Cherwell District Council
Planning & Development Services
Bodicote House White Post Road
Bodicote
Banbury
OX15 4AA

Our ref: WA/2021/129037/03-L01
Your ref: 21/01119/OUT
Date: 16 January 2023

Outline planning application for the re-development of the Banbury oil depot to include the demolition/removal of buildings and other structures associated with the oil depot use and the erection of up to 143 apartments and up to 166m² of community and/or retail and/or commercial space (class use E and/or F2) with all matters (relating to appearance landscaping, scale and layout) reserved except for access off tramway road

Q8 Fuelcare, Tramway Road, Banbury, OX16 5TD

Figure 7-1: Flood Depths - Defended 0.1% annual probability (1 in 1000 year) event – Station

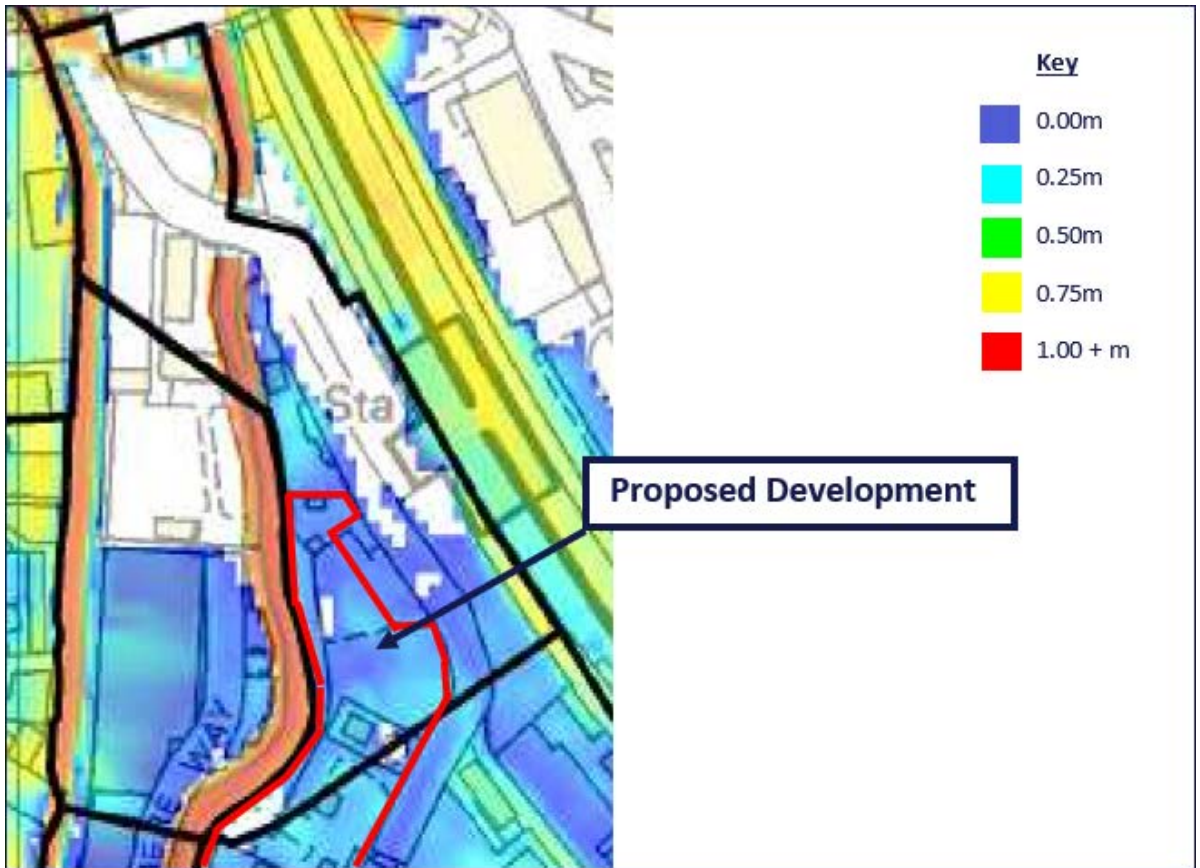
The modelling has been run to identify flood risk in relation to a 49% increase in peak river conditions due to climate change. This is the upper end and most extreme climate change prediction for this catchment as shown in current guidance and will therefore represent a worst-case scenario. The model results represented in Appendix A, show that the development will displace flood water and increase flood risk elsewhere. This means for development to proceed on this site, based on the flood risk currently identified, compensation for any expected lost flood storage would be needed. Due to the extent of identified flooding in this extreme scenario, on site compensation for lost

flood storage would not be possible. This means the development would fail both national and local planning policy and the flood risk exception test.

However, the applicant has not provided details of any of the other climate change scenarios for this catchment and to proceed with detailed designs based on this extreme representation of flooding is unlikely to result in a viable development. The applicant needs to also consider the higher central climate change scenario (25%). Should this result in increased flood risk to the nearby rail station and tracks, compensation to address this will need to be designed and shown to be feasible in order for planning permission to be granted. Should the rail station and be unaffected by the development proposal using the 25% scenario, then it may only be necessary to consider the central climate change allowance of 15%.

The applicant will need to demonstrate that development on this site can be designed to remain safe without increasing flood risk elsewhere both now and in the future using the relevant climate change scenario. Sufficient evidence should be presented to ensure that the risk of flooding at the site is clearly understood, including the expected extent of flooding that may be experienced and identify the flood depth/s across the site. They will then need to show that a viable development can be designed to meet planning policy requirements. This includes providing details of the current built footprint on site and potential development parameters in response to the identified risk of flooding which will provide the necessary confidence to the Planning Authority that flood risk can be properly controlled. The Flood Risk and Coastal Change Planning Practice Guidance offers advice on how this should be considered including the need to consider potential breaches or overtopping of flood defences which offer some protection to this site.
